**Application by Mallard Pass Solar Farm Limited for an Order Granting Development Consent
for the Mallard Pass Solar Project – project ref. EN010127**

Submission by Mallard Pass Action Group (MPAG) – unique ID ref. 20036230

Deadline 1: Suggested Locations for Site Inspection

Traffic Regulation Measures Plans - Temporary Measures

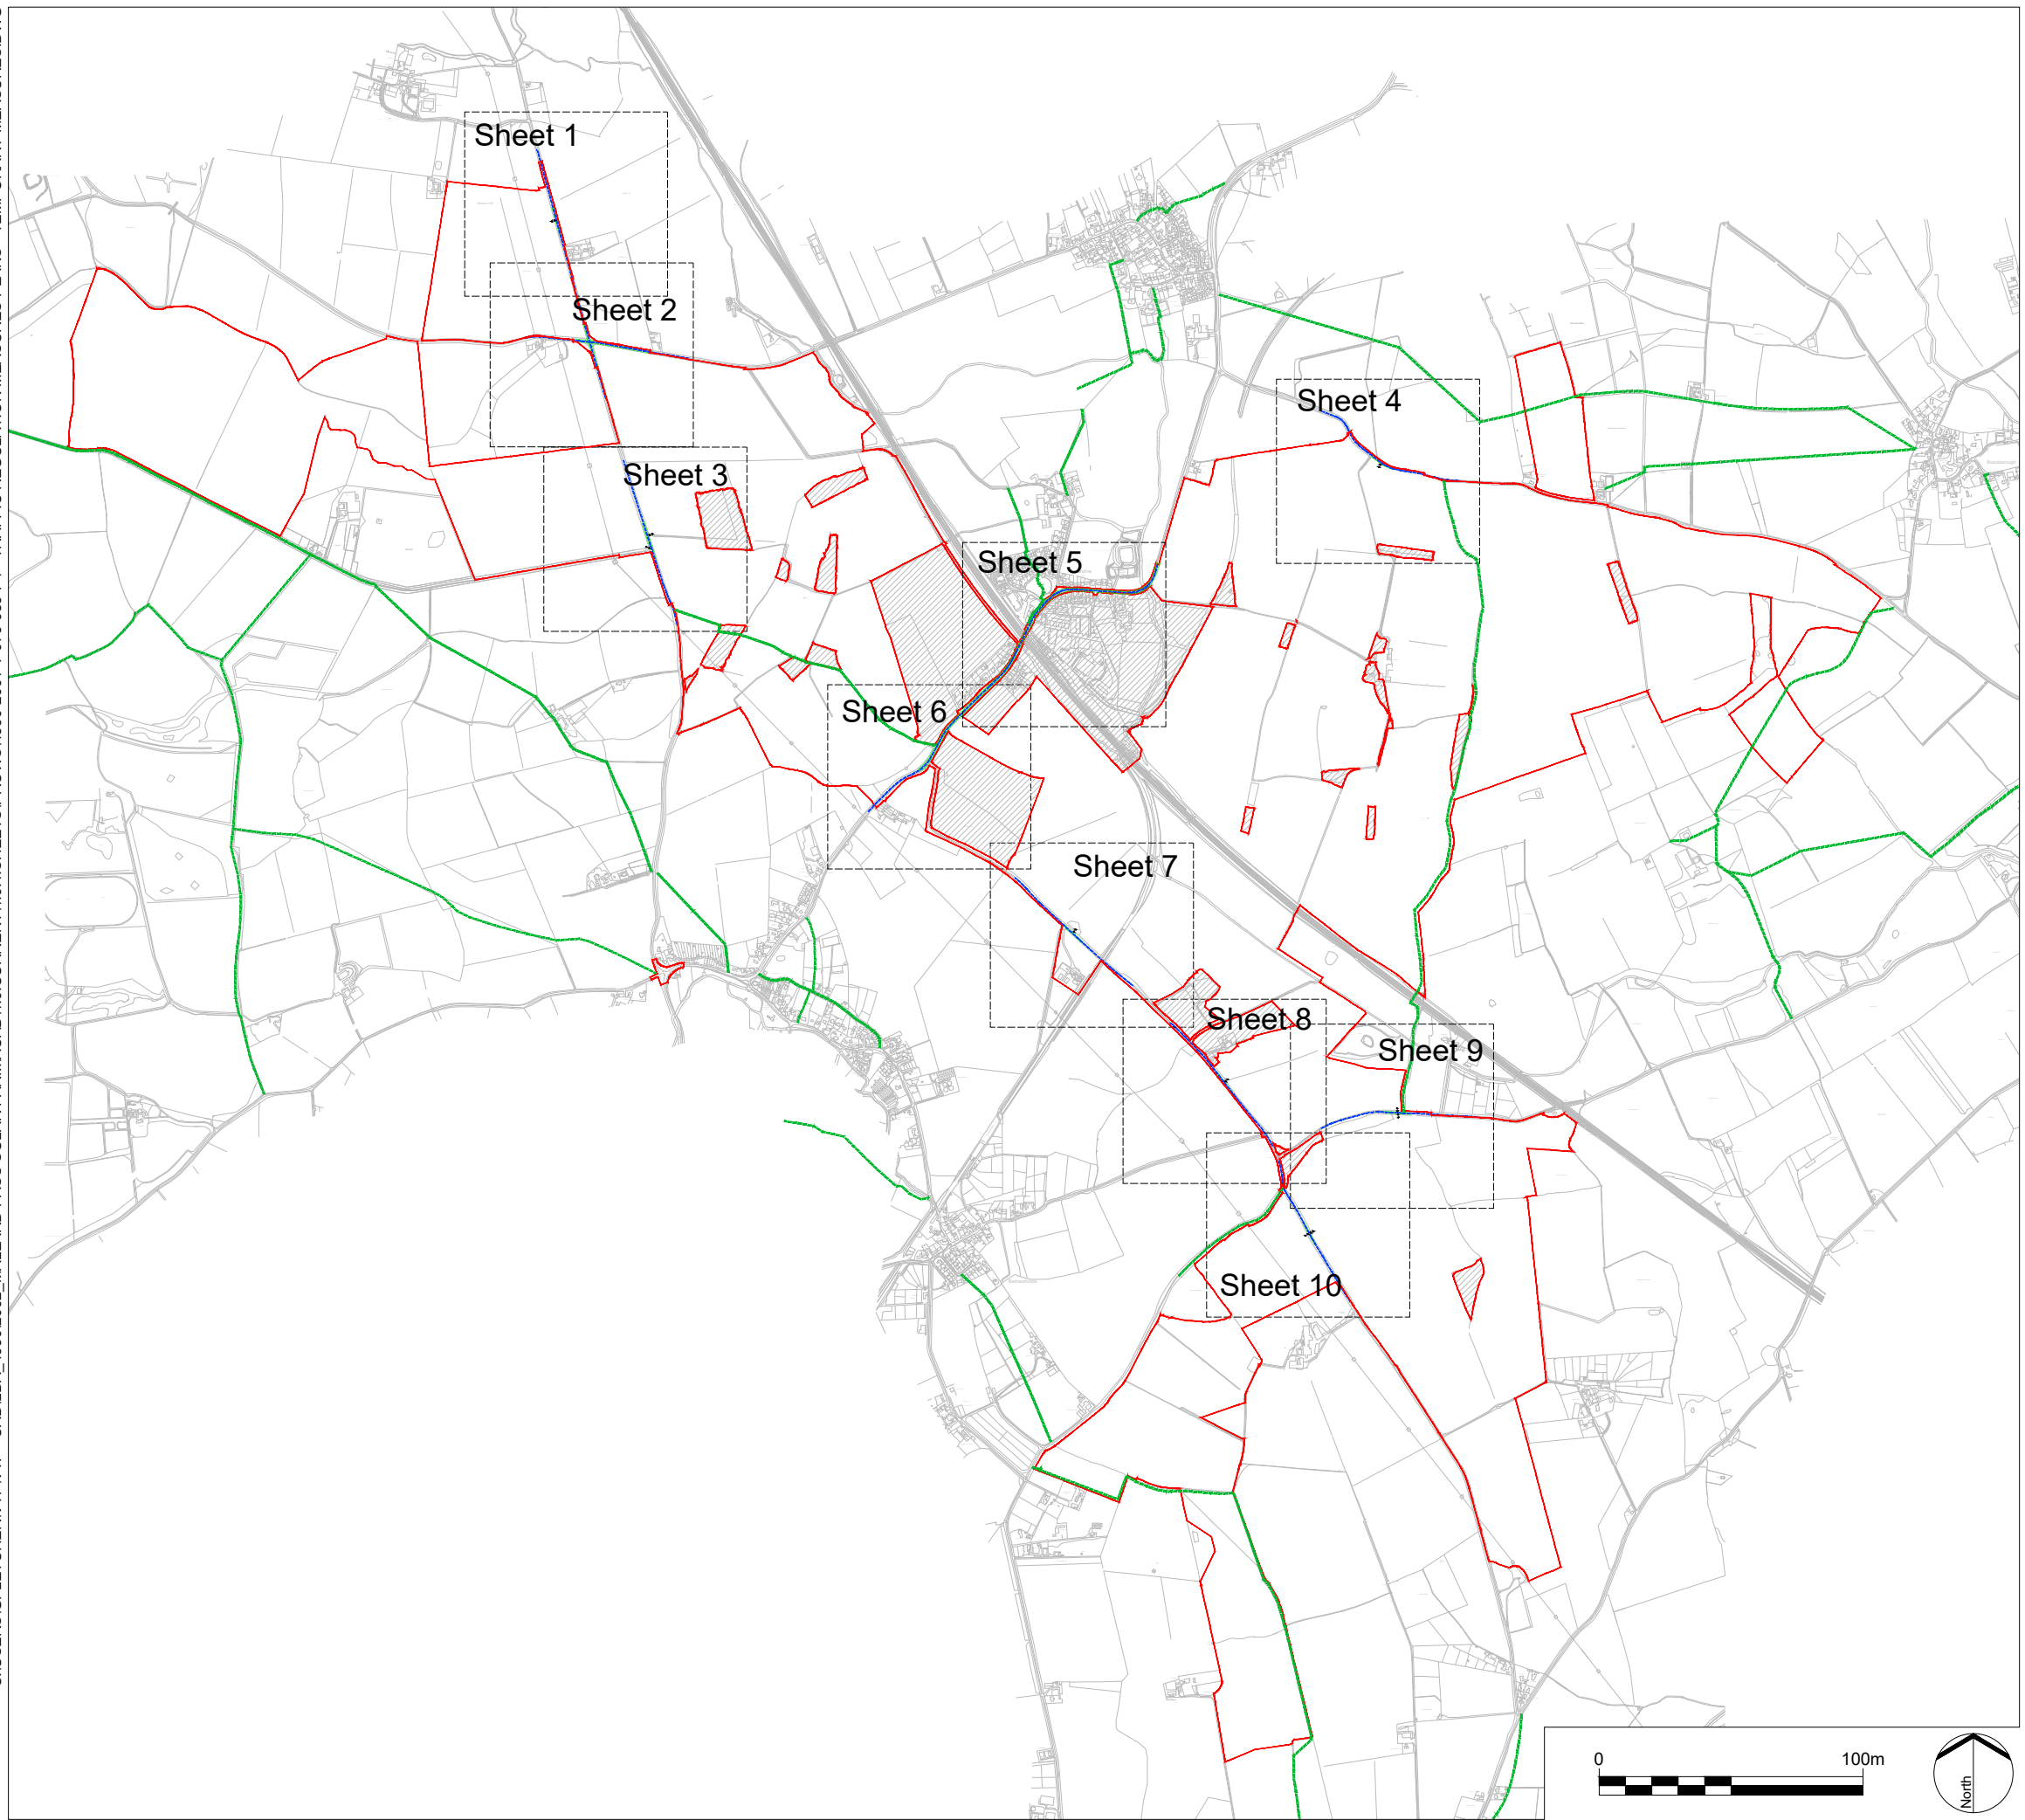
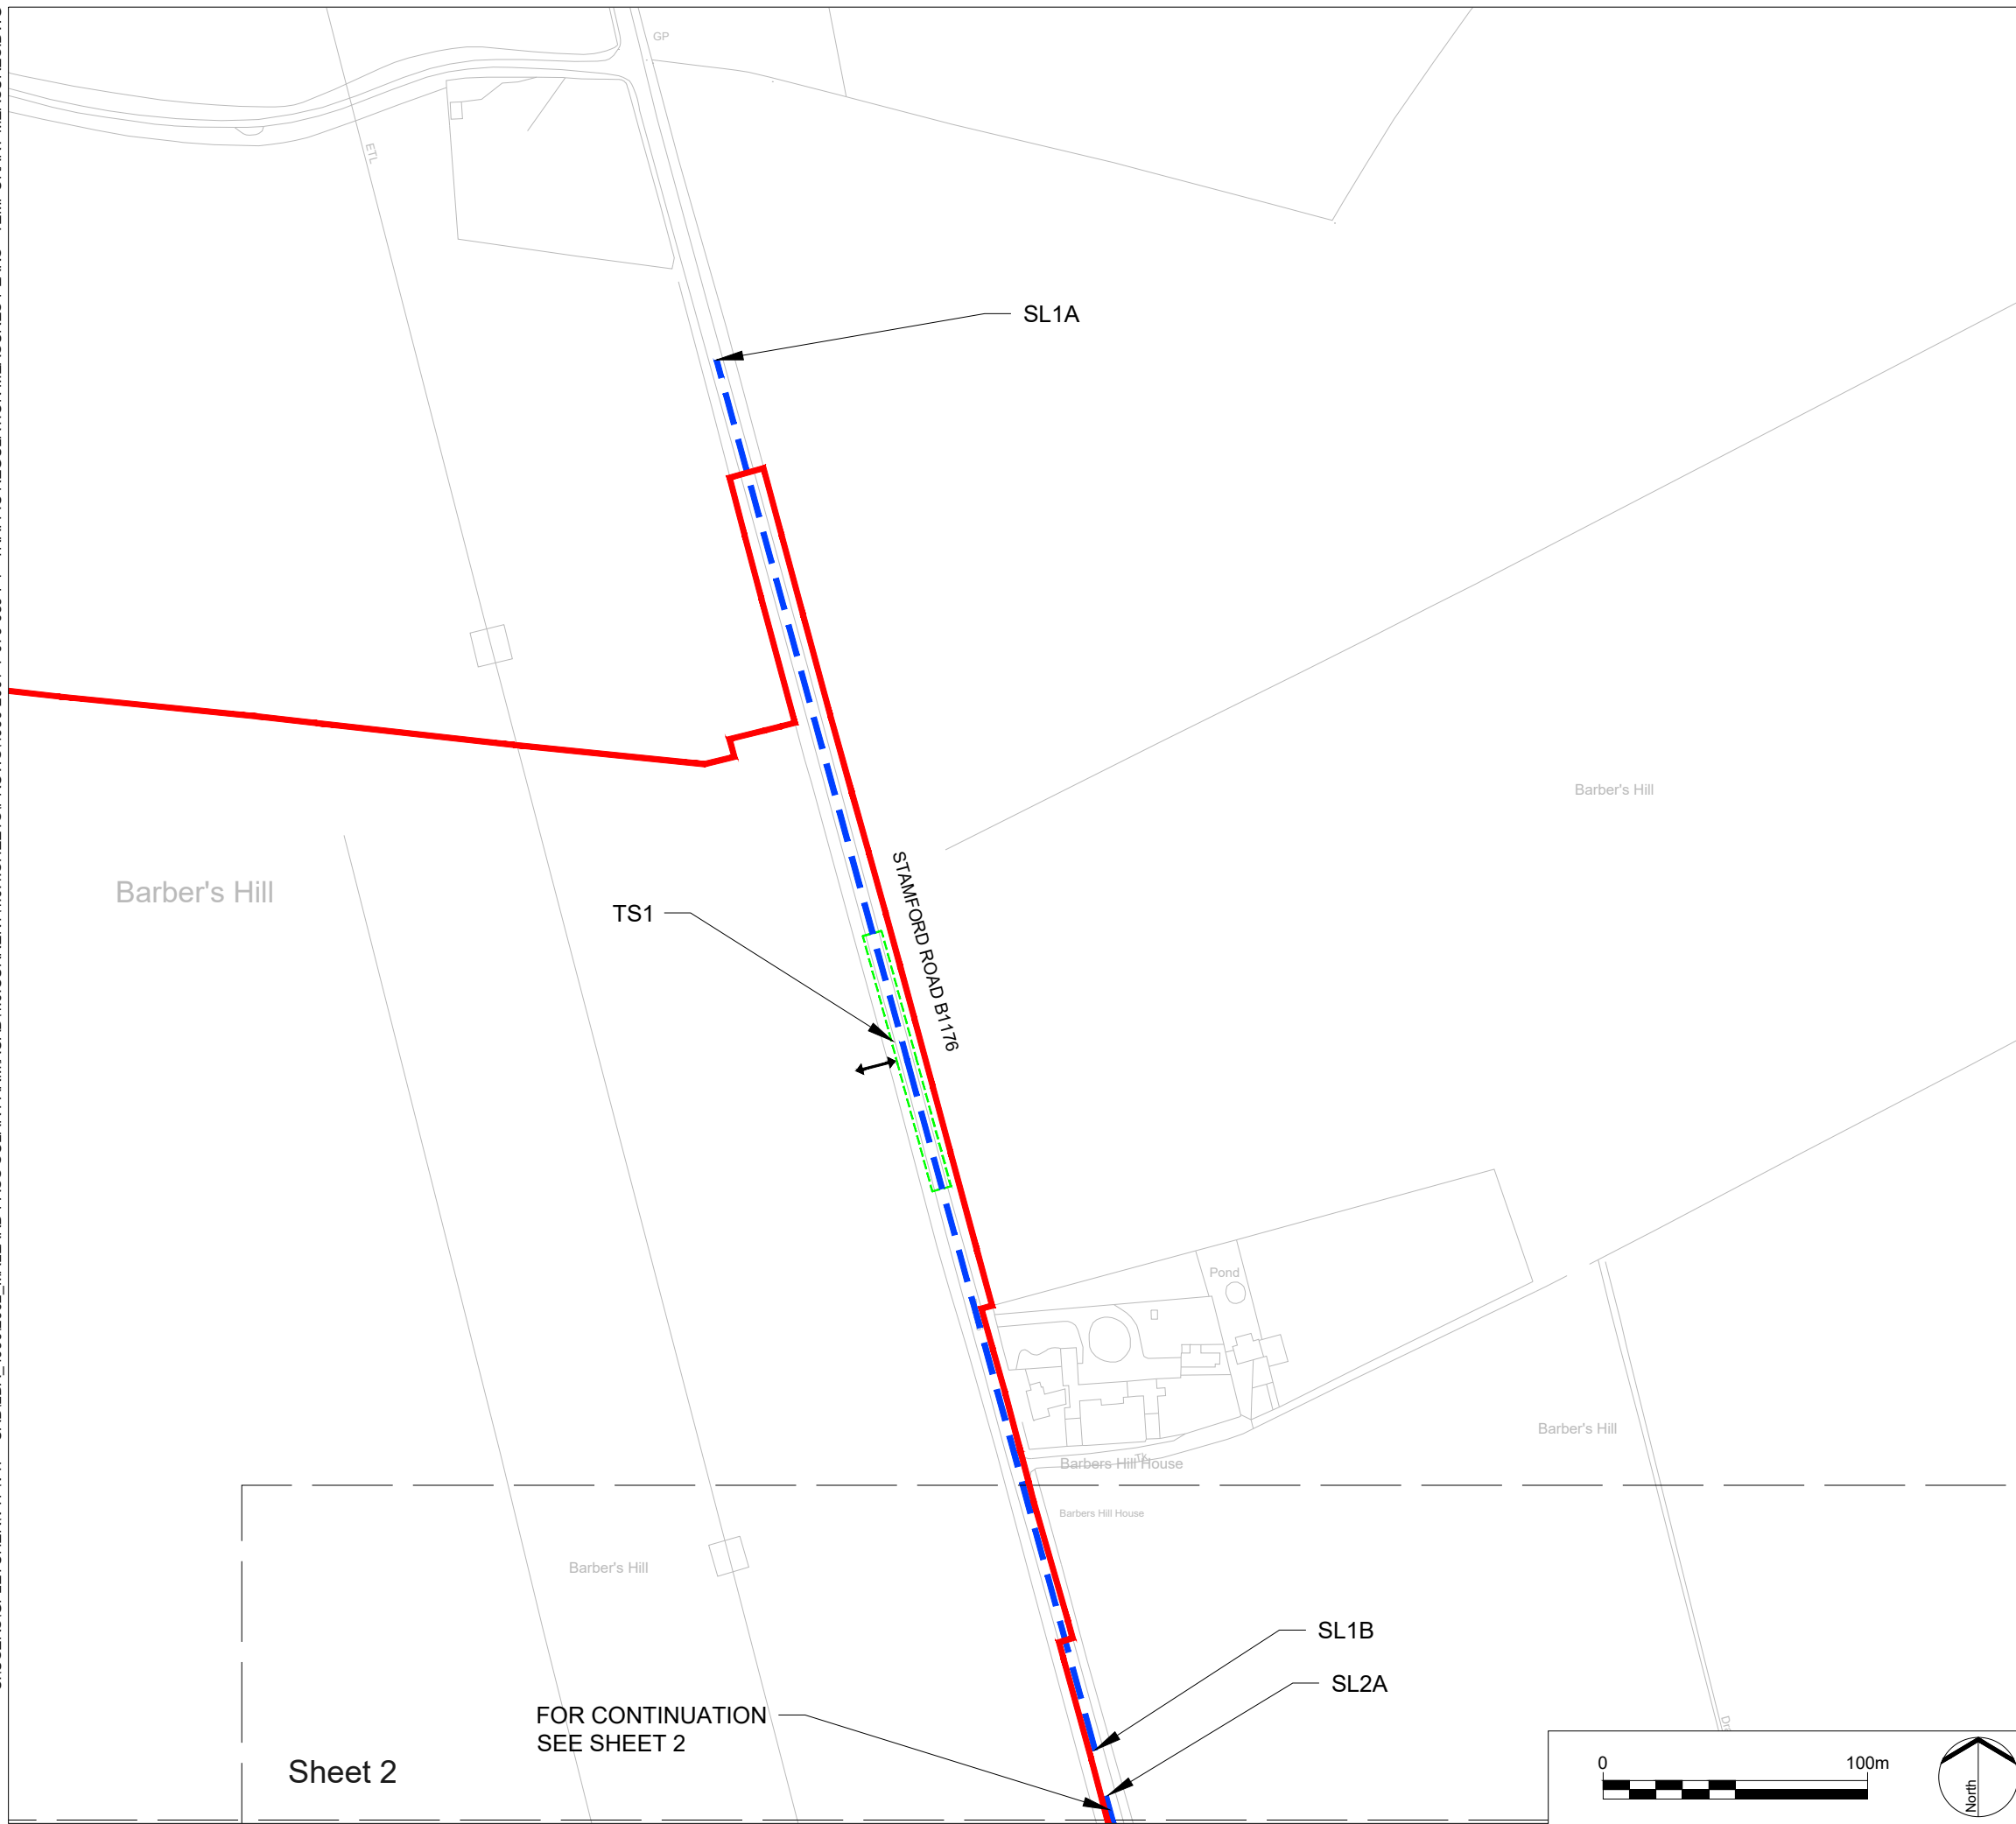
- Site Access. P11 of document '2.7 Traffic Regulation Measures – Temporary measures' (AS-008) shows 2 access locations right next to PRow/1/1 bridleway and in very close proximity to Banthorpe Lodge. Document 'Solar PV Site Access Locations' (APP-130) only shows 1 access location, MPAG assume this

document is out of date as AS-008 has been more recently submitted. Not only is this considered a safety aspect for the bridleway but the proximity to Banthorpe Lodge is too close.
